KITTITAS COUNTY

MEMORANDUM

TO: All Staff
FROM: Justin Turnbull, County Surveyor 
DATE: August 23, 2017
SUBJECT: County Survey Review of Boundary Line Adjustment 17-00015 (Kohl)

BOUNDARY LINE ADJUSTMENT
 PREPARED FOR
 PETER KOHL
 A PORTION OF THE SW 1/4 OF THE NE 1/4 OF SECTION 4,
 TOWNSHIP 19 NORTH, RANGE 15 EAST, W.M.

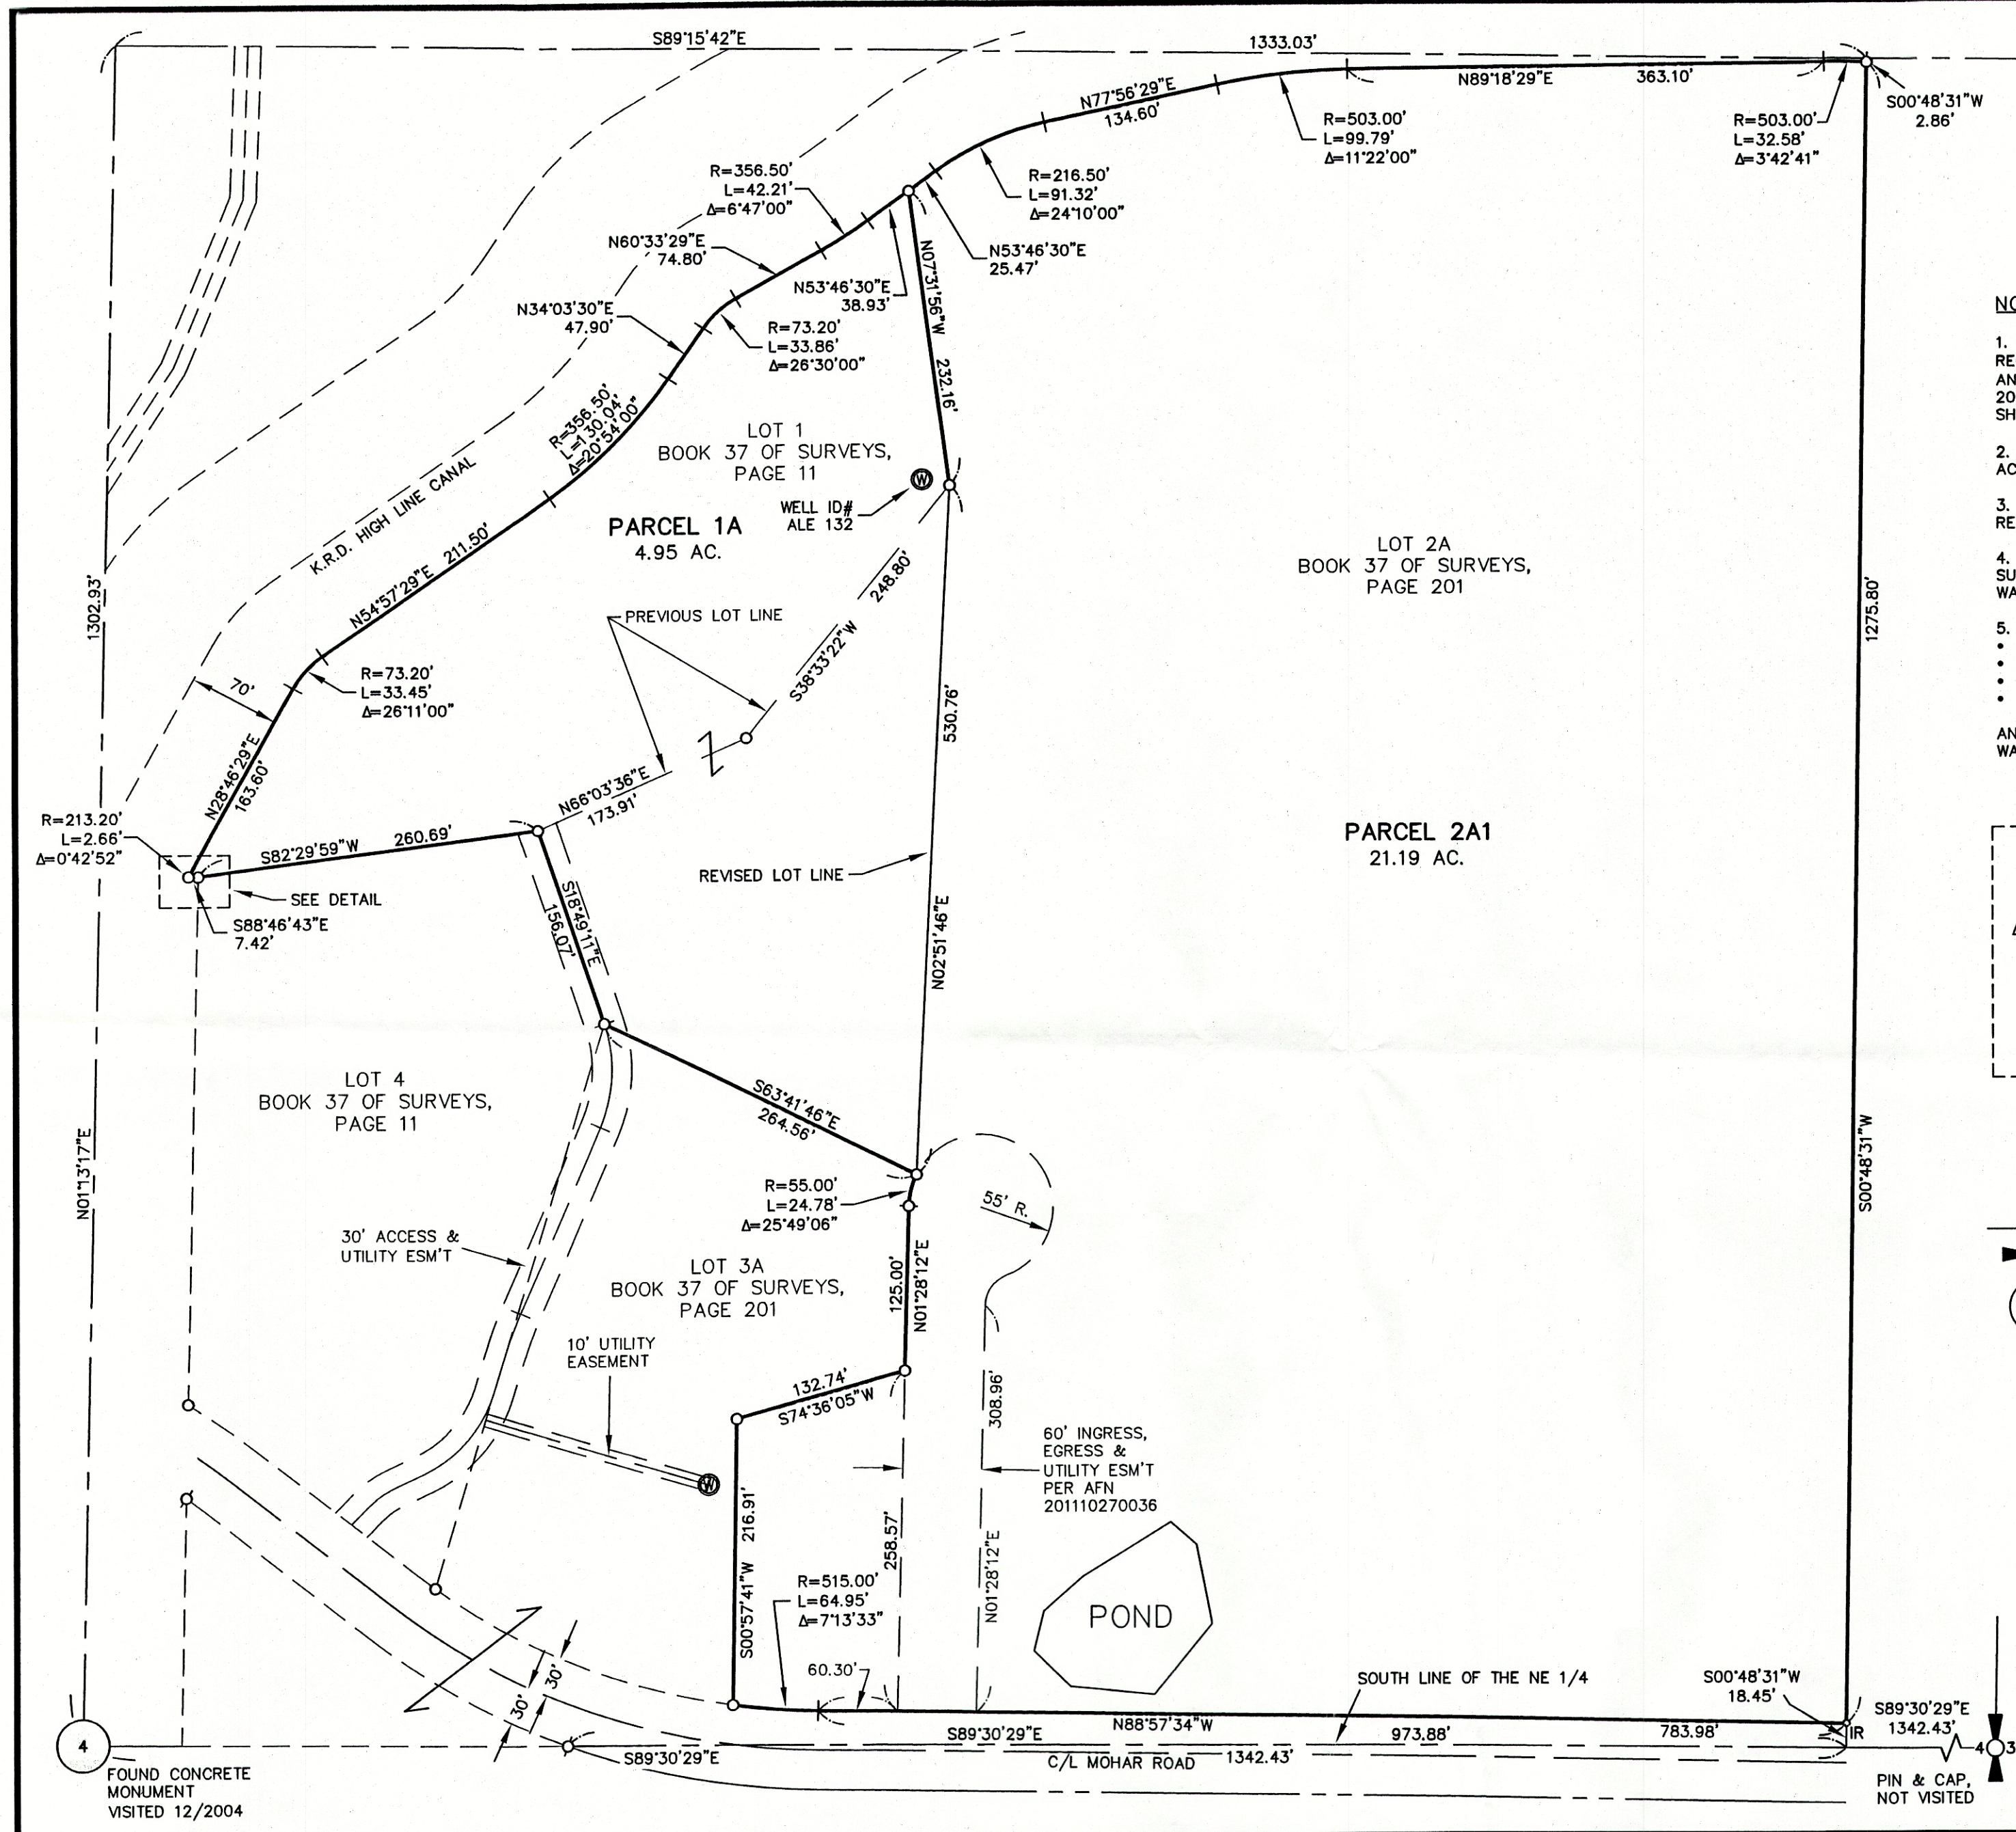
1. Roadways should include name, width, ownership (private/ state/ county) surfacing material and R/W or easement. (EX: Mohar Rd. – 60' County R/W – Paved)
2. Easements should include recording number. In the absence of record documents, include a note detailing the surveys of record identifying the easement, to substantiate any prescriptive rights.
3. Please include the LS Number of "Found Iron Rod & Cap"
